Consultation Response from KC Highways Development Management		
2026/90211 West House, Oxford Road, Gomersal, Cleckheaton, BD19 4AU		
Erection of residential development for 9 dwellings with associated works		
Date Responded: 30/03/26	Responding Officer: M Zenner	Responding Ref: K8-9NW/7

RECOMMENDATION: Some amendments and further information is required to assess the highways implications of the proposals.

Proposed Site Plan - Overall 1 : 500

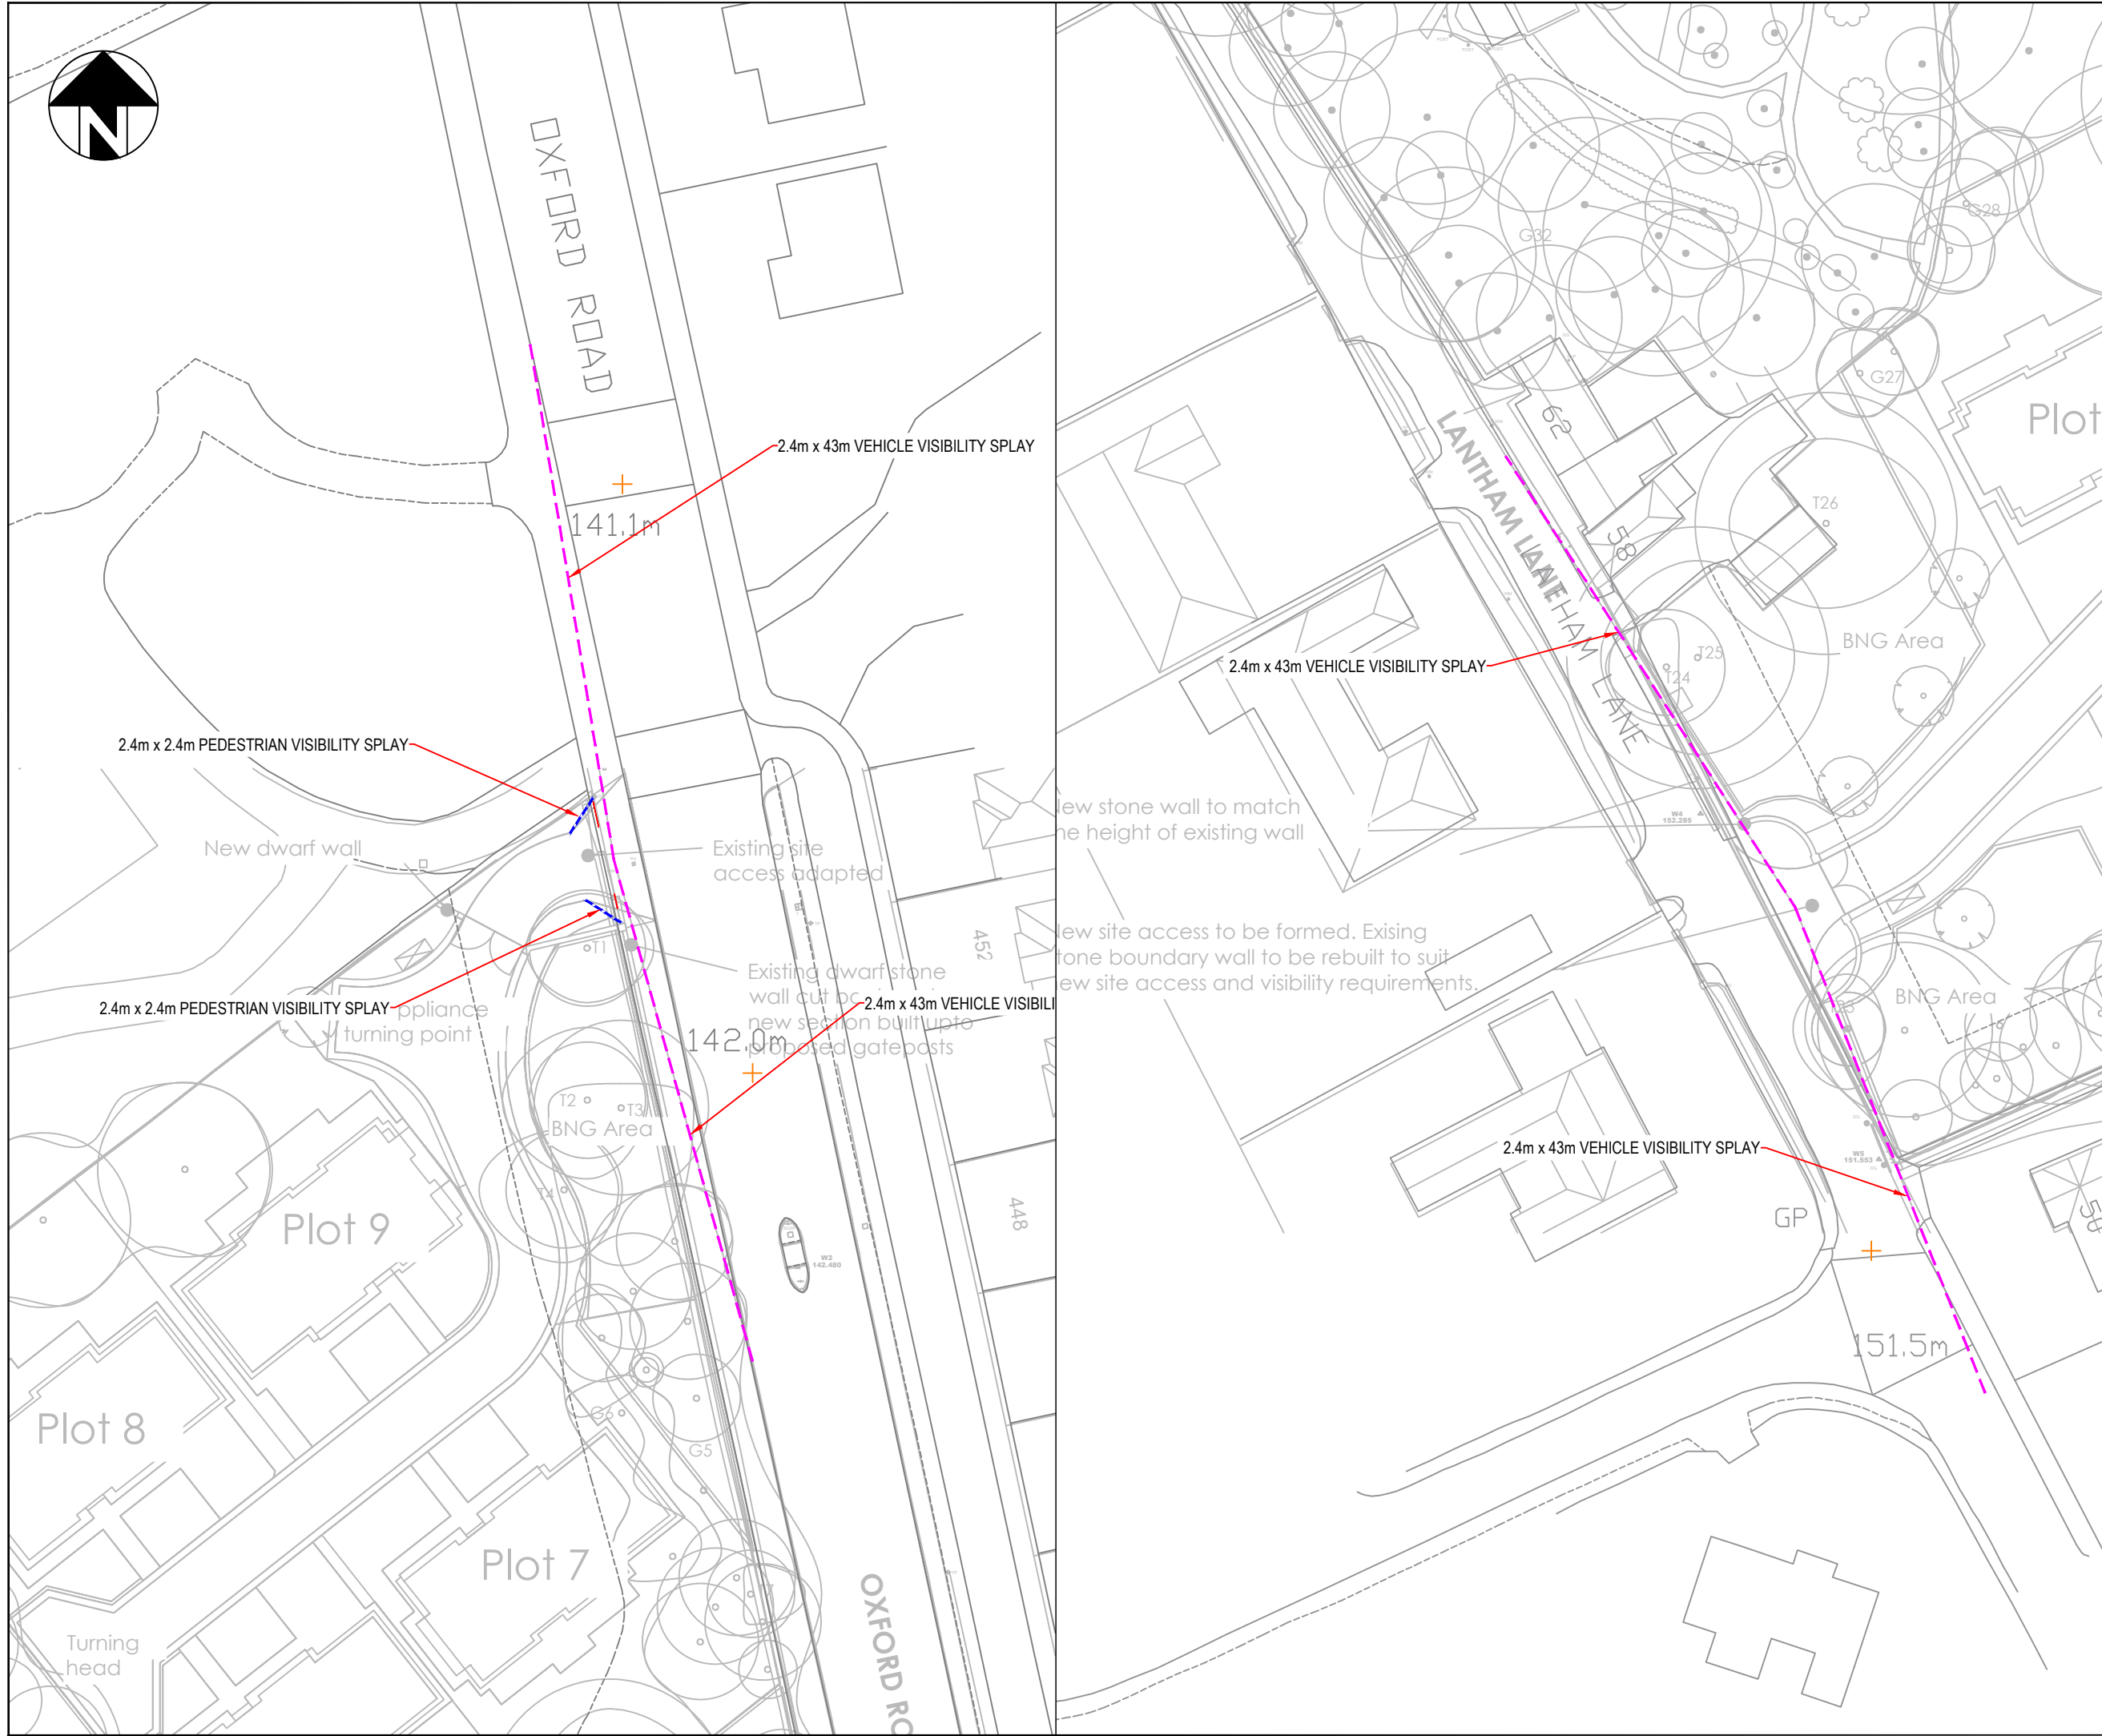
- Swept paths required for the Oxford Road site access.
- The gates on the Oxford Road frontage should be set back to beyond the turning area.
- Visitor Parking should be provided within the site.
- Bin presentation points should be reviewed, the LHA is concerned there may not be sufficient capacity in the proposed facilities. Stores should be accessible and not located behind gates.
- A 2m wide footway should be provided along the site frontage on Latham Lane.

The proposal includes amendments to the existing site access to widen the access point to allow simultaneous access and egress. The proposed access appears to be approximately 5.5m wide and whilst this is acceptable in principle, it is noted that there is an immediate bend to the access road which may impede access, therefore the LHA would recommend a swept path is undertaken to demonstrate two large cars can pass acceptably at the proposed access to ensure that blocking back onto Oxford Road would not result from the proposals. Furthermore, the LHA would recommend that the gates proposed at the entrance are set back beyond the turning point to aid vehicles servicing the site to exit the site in forward gear. Such an amendment would also ensure the bin collection point is accessible.

It is the LHA's understanding that the road is proposed to remain private and as such the LHA would recommend a continuous footway rather than engineered vehicular access.

The proposed junction is proposed to be created whilst rebuilding the existing stone boundary wall which is proposed to be set back to allow the delivery of visibility splays to comply with Manual for Streets for a 30mph road of 2.4m x 43m. It is the LHA's view that as the boundary wall is proposed to be amended to form this access, that the provision of a 2m wide footway should be provided along the site frontage to improve pedestrian access in the vicinity of the site access and to improve access for pedestrians to the closest PROW no SPE/48/10 which is located just south of the site boundary. A continuous footway should be provided at the site access with a simple dropped kerb for vehicle access and egress to the site.

It is noted that the boundary walls are also proposed to be shaped to enable pedestrian visibility at the site entrance, whilst this is acceptable in principle, the LHA would request that any gates should be set back approximately 5m from the back of footway and that the location of the bin presentation point is reconsidered to ensure that it is accessible on collection days and not contained behind gates.

No visitor parking spaces are proposed within the site. Parking places for visitors to residential developments are unlikely to remain available unless suitable arrangements are made to ensure that they would be managed and maintained. Further clarification should be provided and one visitor parking space designated within each part of the proposed development.

The LHA is concerned that the proposed bin presentation points may not be able to accommodate the required level of bins for collection day and may not be accessible if they are located behind gates, further consideration should be given to this.

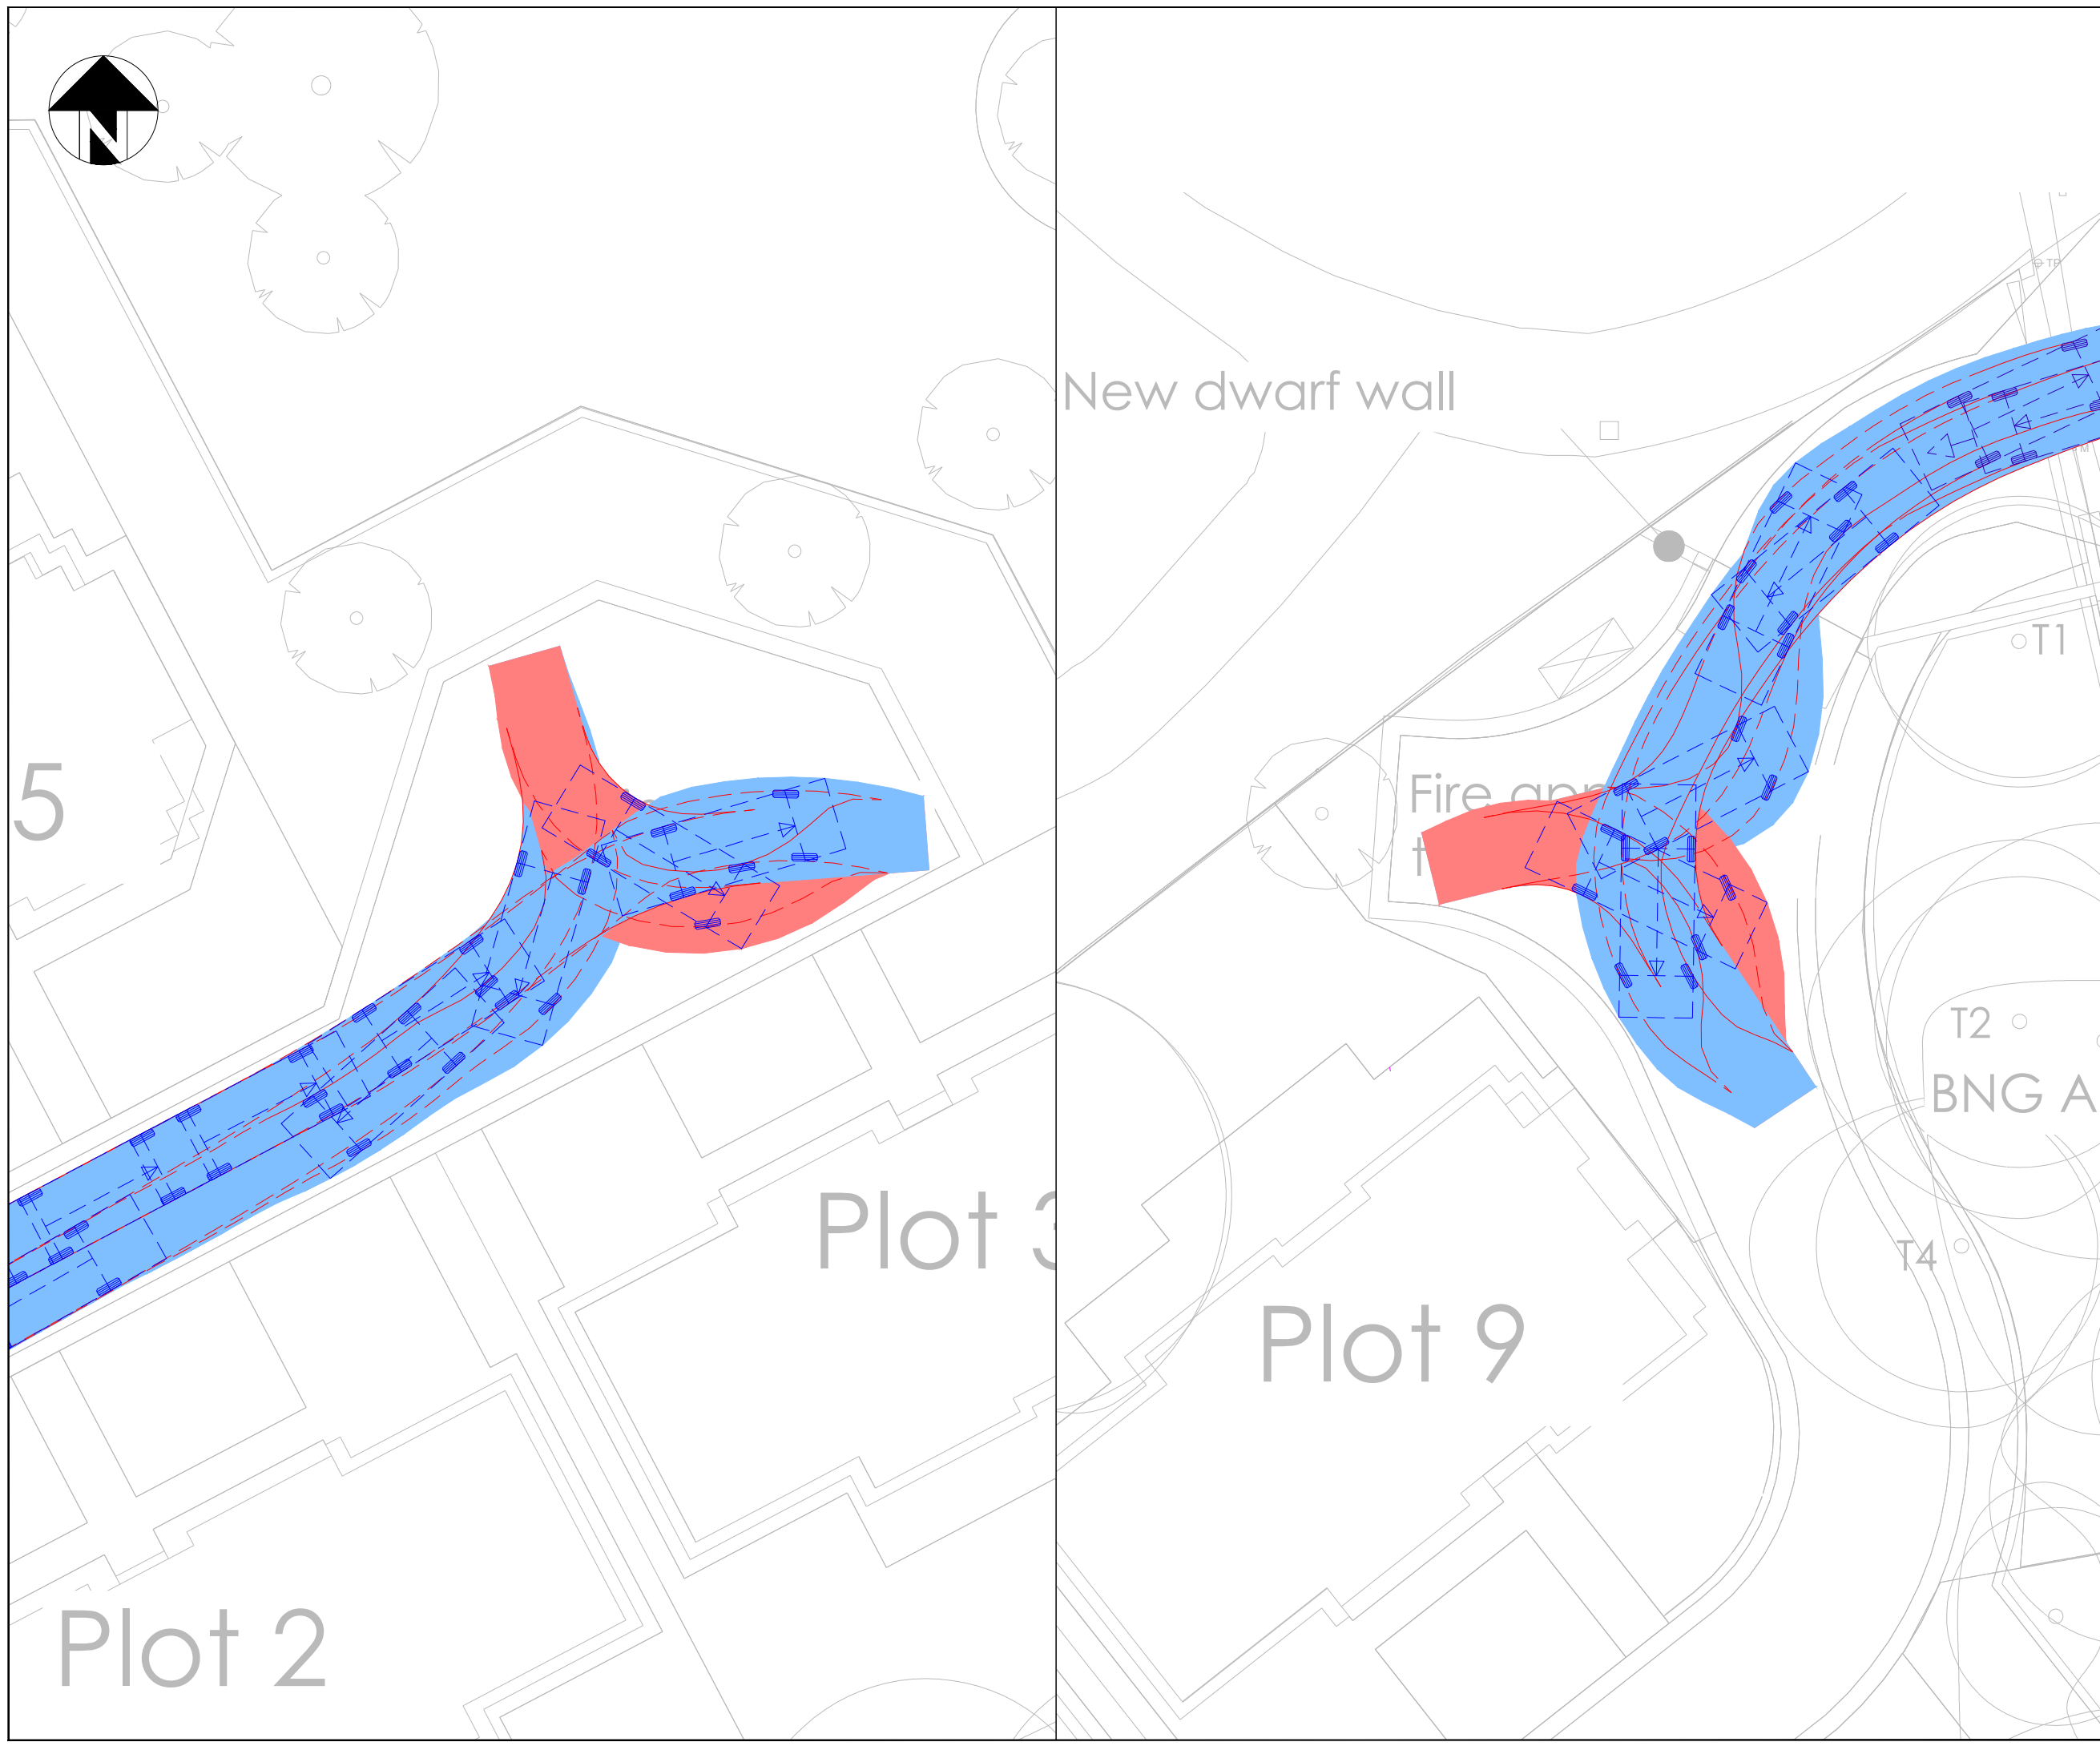
Pedestrian visibility splays of 2.4m x 2.4m have been demonstrated at the site access acceptably and the vehicle visibility splays proposed comply with Manual For Streets requirements for a 30mph road of 2.4m x 43m in either direction.
